Norwich to Tilbury

Update from Priory on current (and long standing) position

1 July 2026

Update post June 12th, 2026 (Teams) meeting and clarification of SoCG standing

Figure 4a: PRIORITY FARM aerodrome’s larger circuit shown in green, the smaller in turquoise. Tracks for departing aircraft in dark blue from each runway end. Proposed power line infrastructure in red; existing in light blue. All circuit/departure illustrations are approximate.

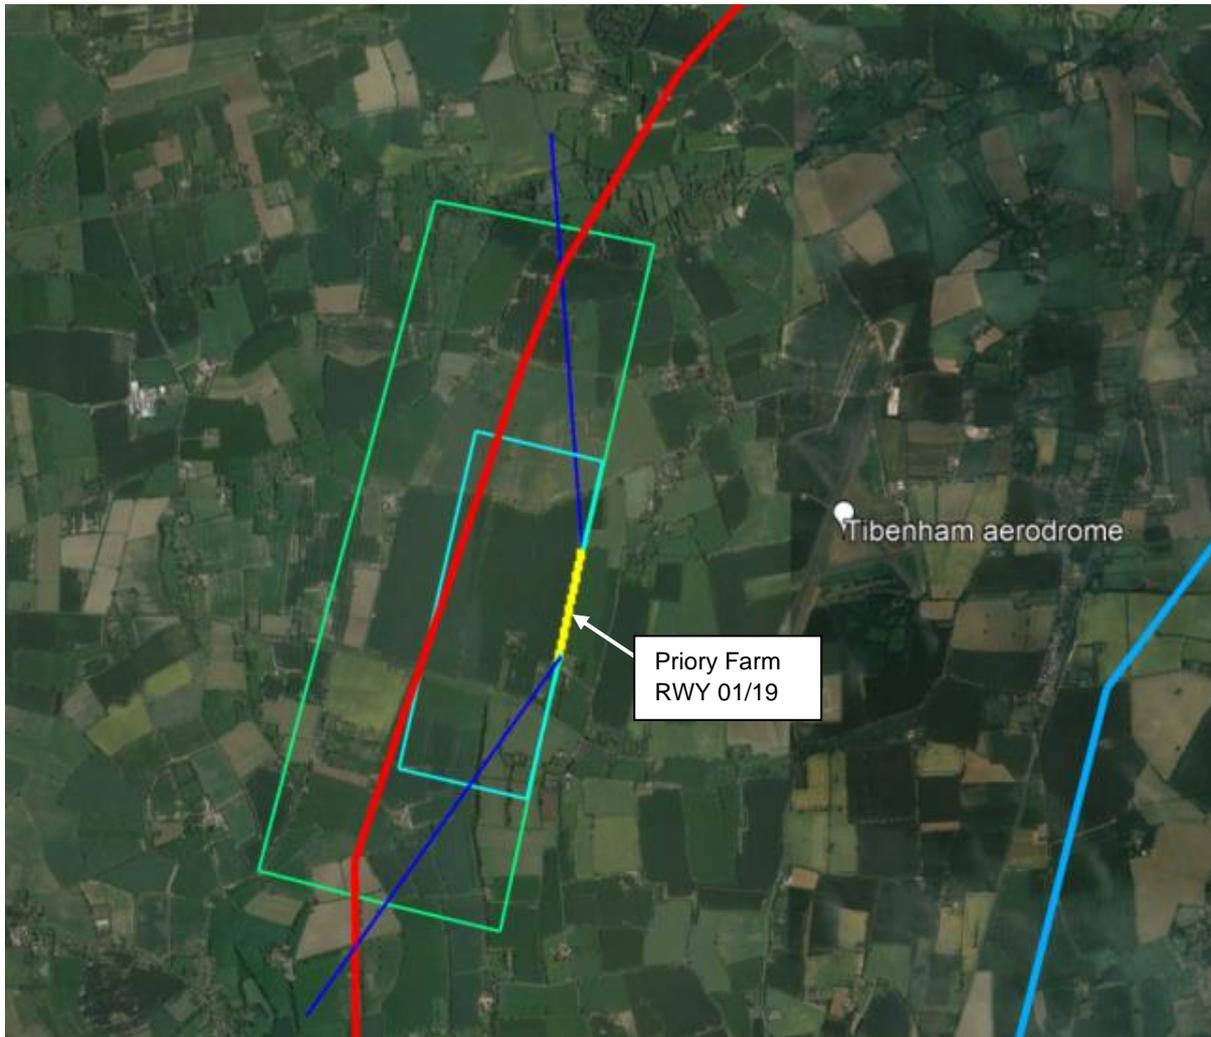
- A quick look at the proposed diagram shows a change in circuit patten TOWARDS Tibenham - something that simply wont be allowed hence ALL our current turns head West of our airfield - this proposes a turn East

- Also, mention of 'old' and 'new' circuits, We never indicated one was a predecessor or successor of the other - BOTH are in active use by differing types of aircraft and experience - typically larger aircraft or new arrivals tend to use the 1000' circuit - smaller and more experienced (to the runway) use the 500'

- Markers don't really serve as a deterrent (although would obviously assist in eyeballing in any emergency)
- The proximity to the existing (and to REMAIN) 500' Priory circuit makes the likelihood of a bad result post any engine issues on departure of EITHER runway untenable.

It may not actually overfly – by feet... but the proximity makes it a very significant danger, particularly at the extremities of the downwind leg
